Review of the Noise Conditions – Calga Sand Quarry

Including a review of a Specialist Report and a supplementary report by Wilkinson Murray and supplementary independent review by Renzo Tonin.

1 Background

NOTES:

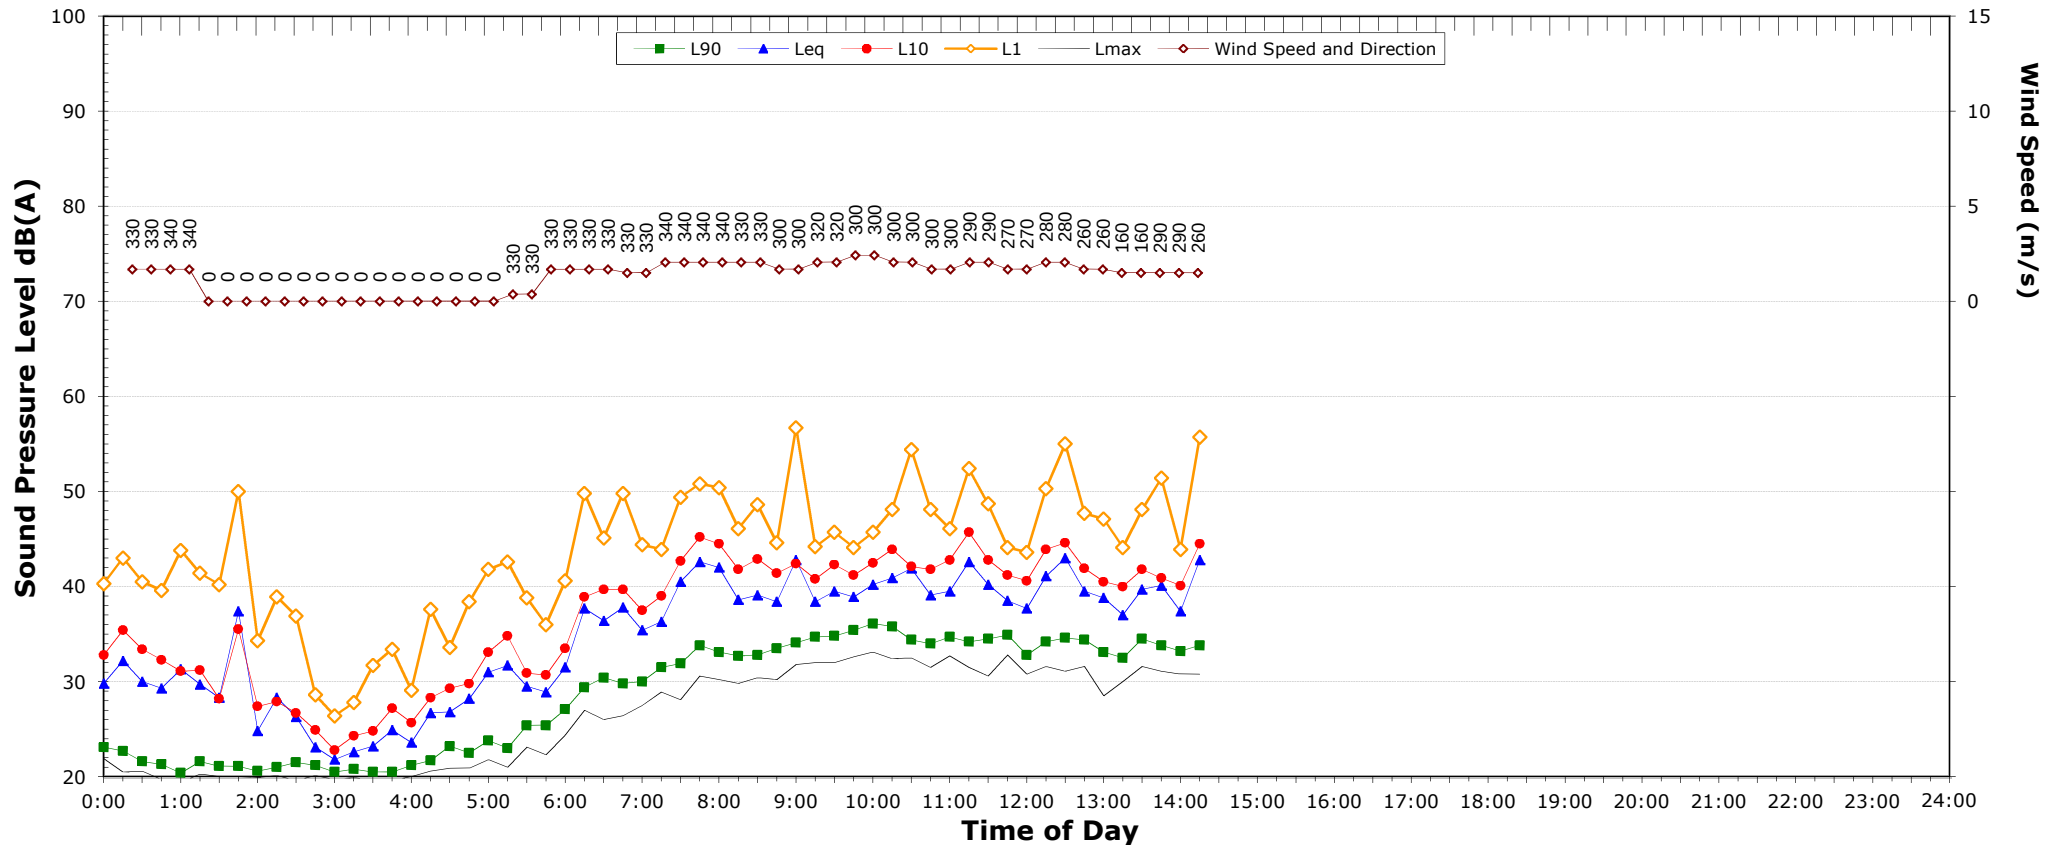
The Renzo Tonin report reports slightly lower background noise levels in its 2013 report, however it is noted that the data was collected under almost continuous northerly winds which are not only non-typical (generally occur less than 5% of the time and would not be considered valid typical monitoring conditions under the Industrial Noise Policy), but also would tend to attenuate road traffic noise, particularly that from the M1 Pacific Motorway. The background noise results contained in the Renzo Tonin report are not consistent with other projects adjacent to the M1 Motorway, which tend to demonstrate that traffic noise underpins the background noise levels throughout the night, and increases significantly from 5am.

Most importantly however, is the collection period only covered 5 mornings including a Sunday on which no work is undertaken, yet was included in the average RBL data set.

Whilst the Renzo Tonin graphs show that the background noise levels recorded during 'working mornings' range from around Leq(15 min) of 30 dB(A) to over 40 dB(A) with an average of around 37 dB(A), the morning shoulder is only a two hour period making it statistically difficult to determine a representative RBL even if a typical range of meteorological conditions are experienced.

The data in the Renzo Tonin report is suitable for assessing the noise impact of the quarry under worst case scenario, however because of the non-typical meteorological conditions and the limited duration of monitoring, it is not suitable for use in determining a RBL. Only the Wilkinson Murray data is considered suitable for the purpose of determining an RBL.
